## SPR EA1N and EA2 PROJECTS

### DEADLINE 9 – COMMENTS ON OTHER DEADLINE 8 SUBMISSIONS

Interested Party: SASES      PINS Refs: 20024106 & 20024110

Date: 15 April 2021      Issue: 1

Figure: 29.17f
Viewpoint 5: Public Right of Way, near Moor Farm

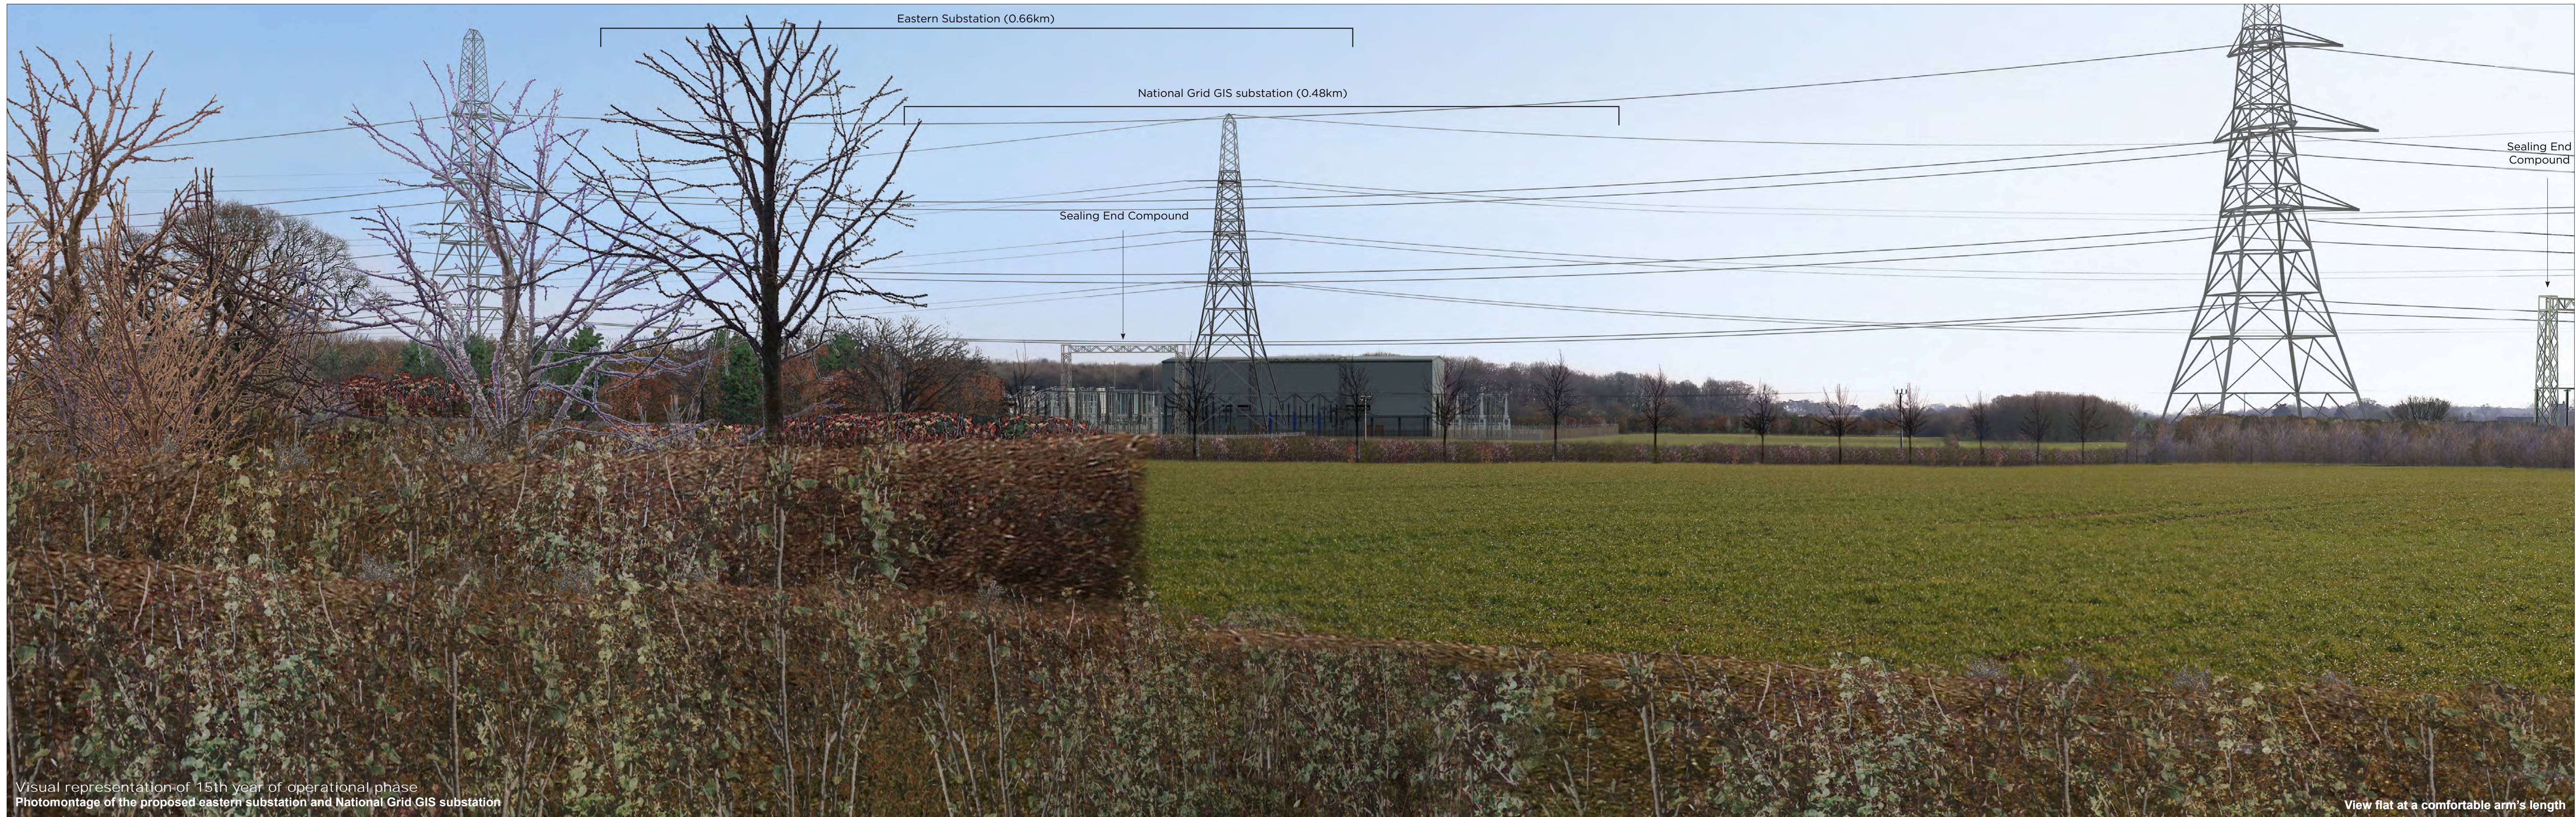
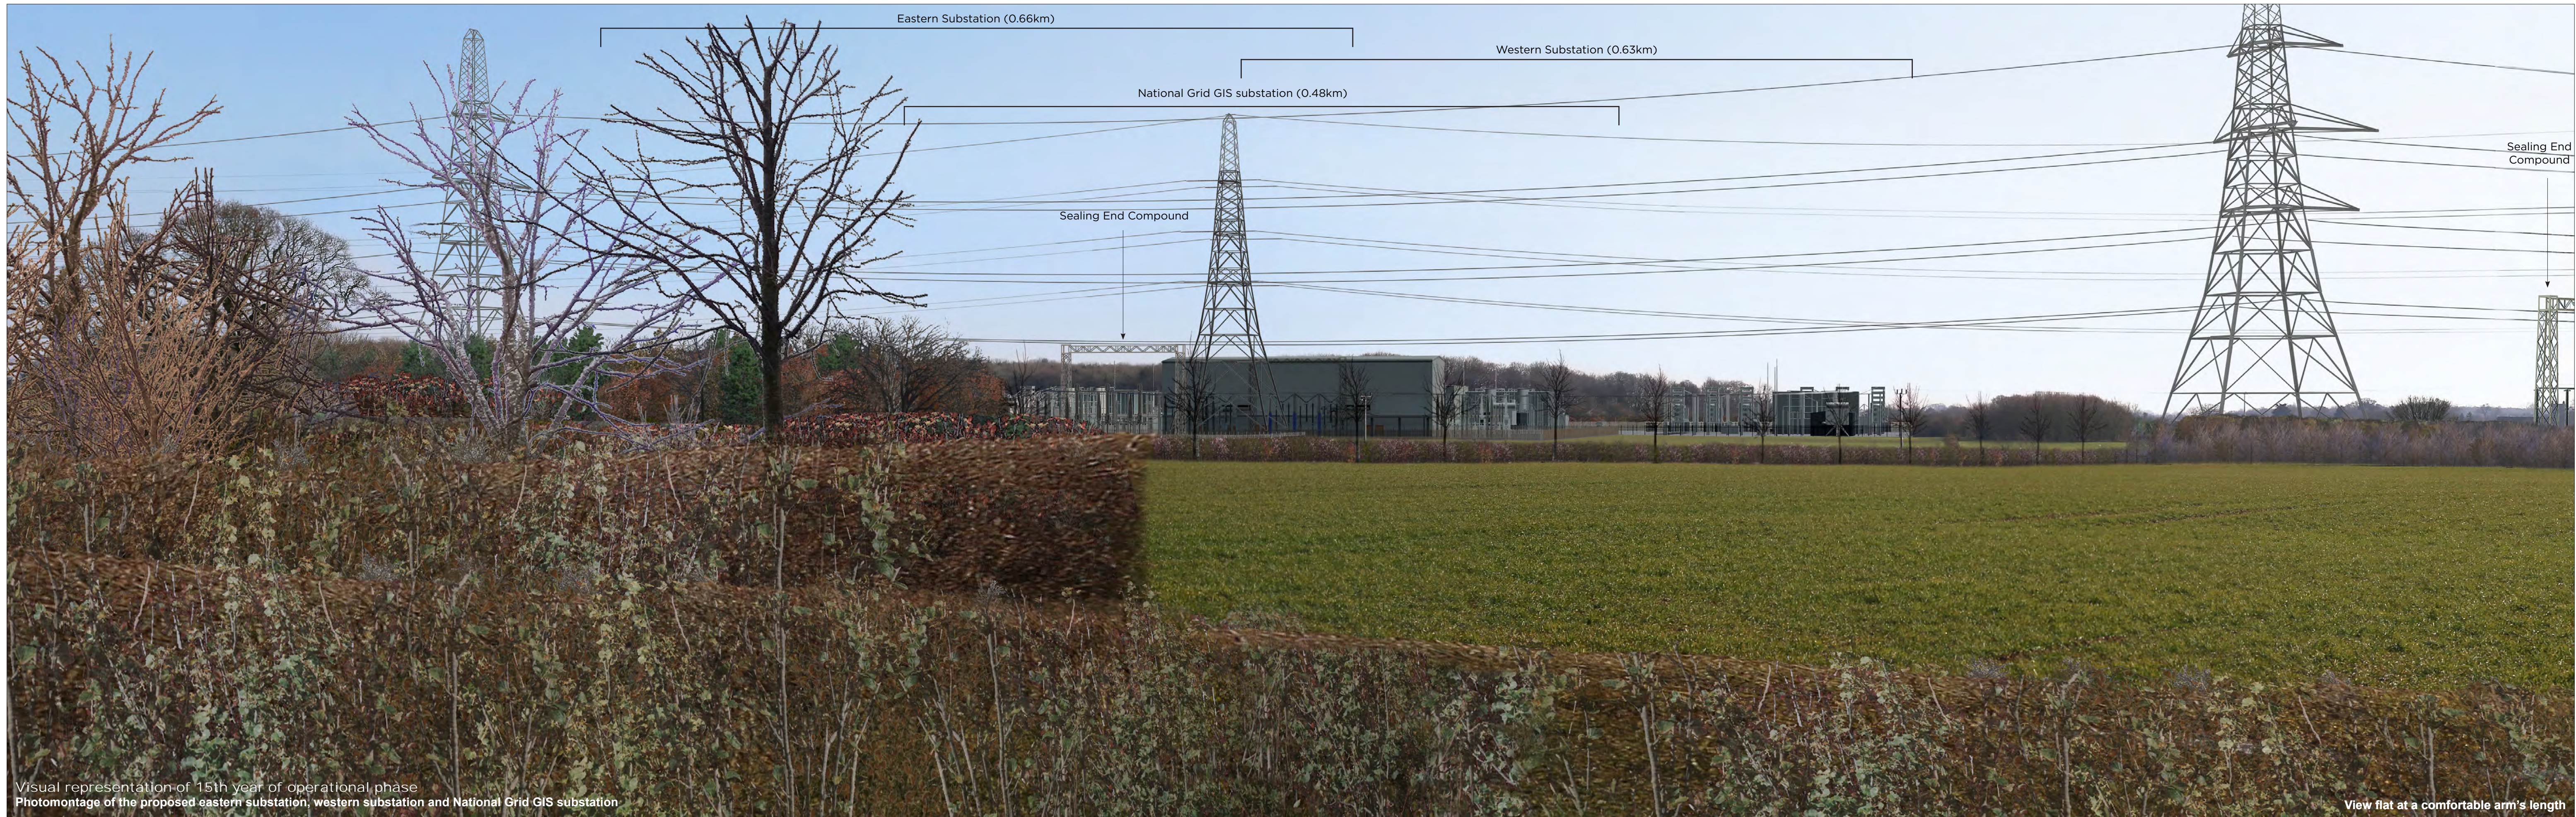
7. The Applicants’ position is that the growth rates will be achieved and the level of mitigation illustrated in the photomontages will be delivered. The question is who should bear the risk of planting not achieving the level of mitigation on which the Applicants rely due to less than forecast growth rates being achieved? This question should also be considered in the context that the local authorities and most interested parties consider the Applicants’ view of the effectiveness of its mitigation is optimistic. Should it be residents and visitors who will have a view of large-scale industrial infrastructure in a rural landscape that bear the risk, or the Applicants which assert that landscape damage will be mitigated by planting?
